Your Ref: OWPC19459
Our Ref: AW/177/18/HH 04-06-2018
Please ask for:
Richard Castro-Parker

Replace windows with double glazed units. Installation of photovoltaic panels.
Installation of 2No. velux windows. Proposed porch. Remove redundant second chimney. Minor reconfigurations to doors & windows & partial rendering to match existing. This application affects the character and appearance of Craigweil House, Aldwick Conservation Area
Craig Rock Cottage 28 The Drive Aldwick

I write with regard to planning application AW/177/18/HH Craig Rock Cottage, 28 The Drive, Aldwick, Bognor Regis. The house is part of the Craigweil House Conservation Area and lies on my eastern boundary. The owners have applied for various renovations which I believe with the exception of one, can only enhance the historic environment of the conservation area.

DATE/DRAWN BY:	27 /04/ 18 Drawn by JS
CLIENT:	Mike & Alison Terry
PROJECT:	28 The Drive, Aldwick
SCALE:	1:100@A3
DRAWING TITLE:	REAR ELEVATION
AS ANDY STEDMAN LANDSCAPE & GARDEN DESIGN

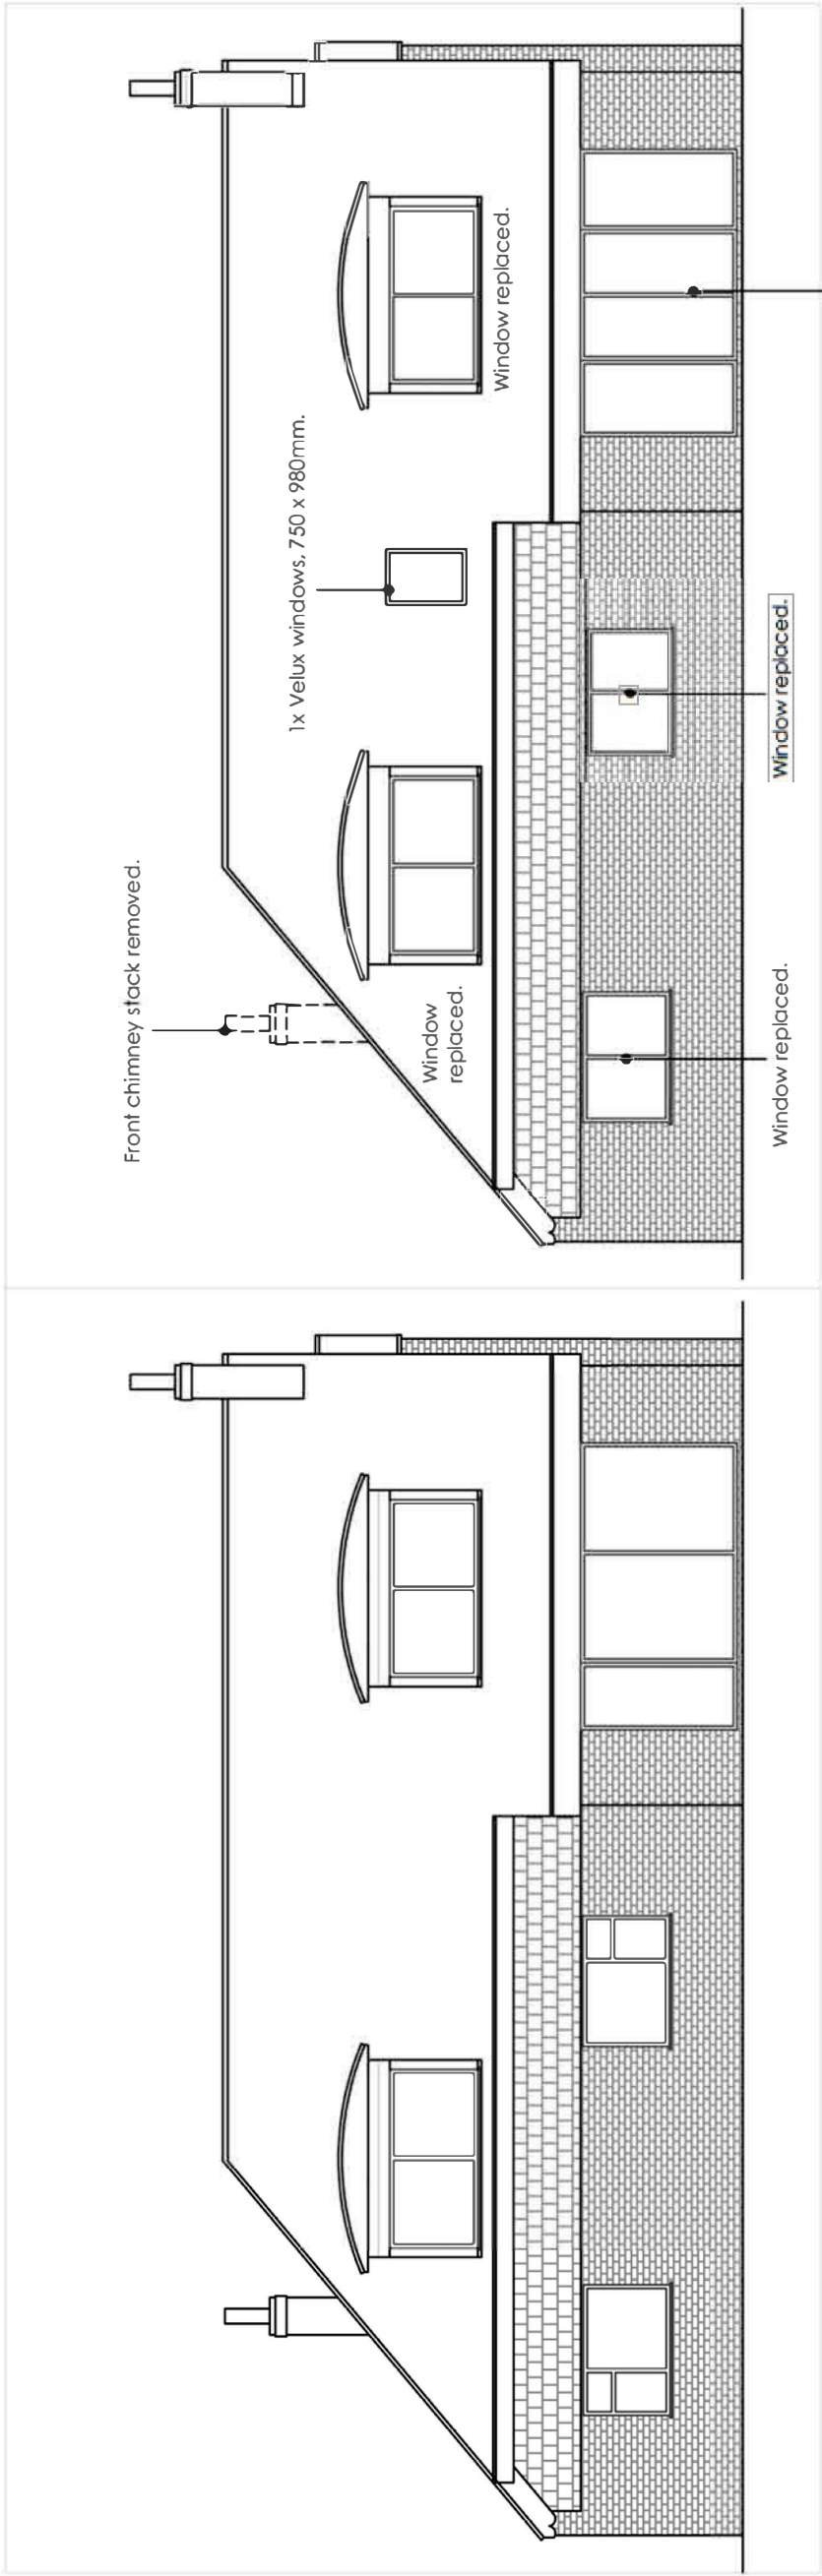
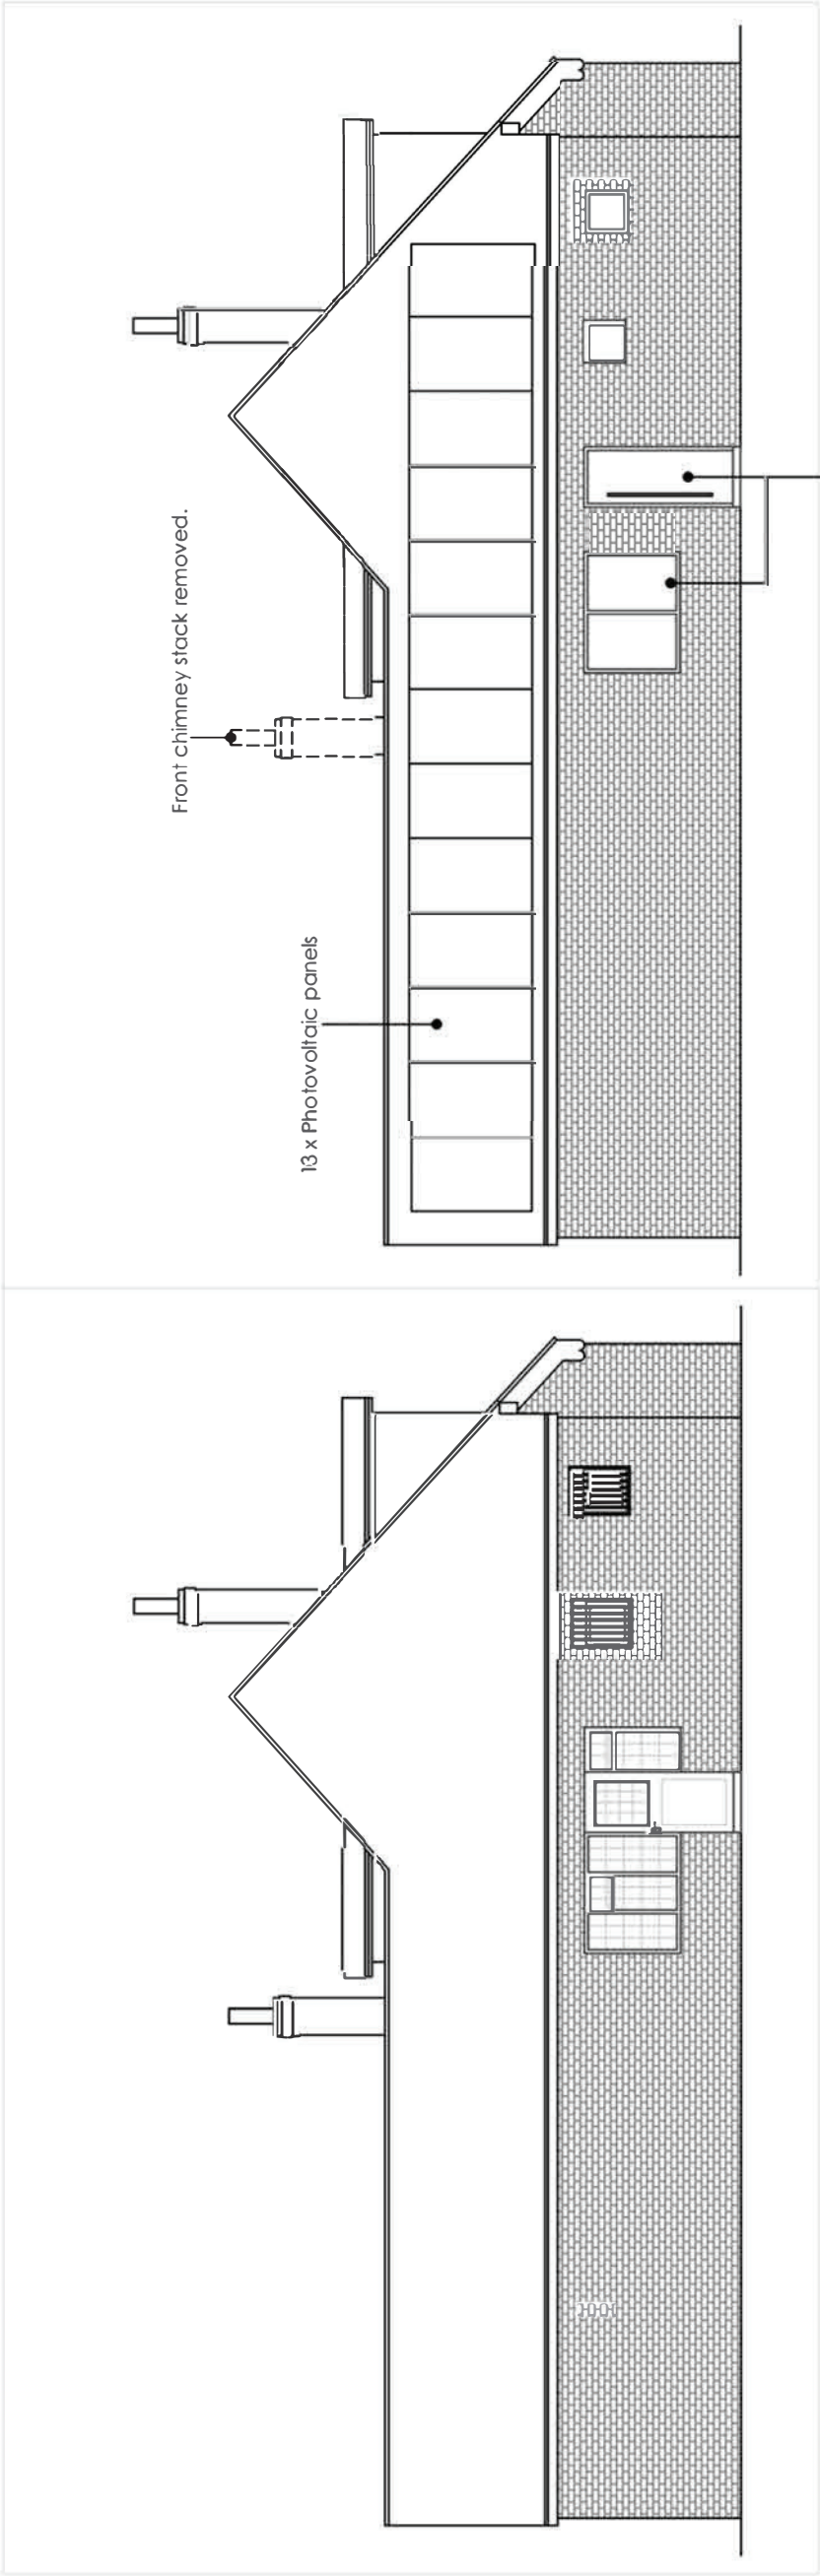
In order to clarify my one objection, I must refer you to the drawing labelled "Rear Elevation" and showing on the roof, a row of 13 photovoltaic panels. This is a typographical error and in fact, shows the west elevation and so is clearly visible from my property. The drawing illustrates the west facing roof of the original building which is constructed of Welsh slate. The proposal is to cover the slate with large photovoltaic panels which will leave very little of the slate visible. This slate is an intrinsic part of the heritage asset of this part of the building which is believed to date from the early 1800s and forms part of the original stable block. The use of these large panels is not sympathetic in detailing nor do they emphasise the features and quality of the existing building as stated in the adopted Arun Local Plan 2011 - 2031 Policy HER DM3b. This is also contrary to Policy HER SP1 as the cells will not conserve or enhance the historic environment of the District.

With reference to renewable energy, as the proposal regarding the photovoltaic cells does not minimise adverse impacts to the historic environment and residential amenity including visual impacts, it is in contravention of Policy ECC DM1.
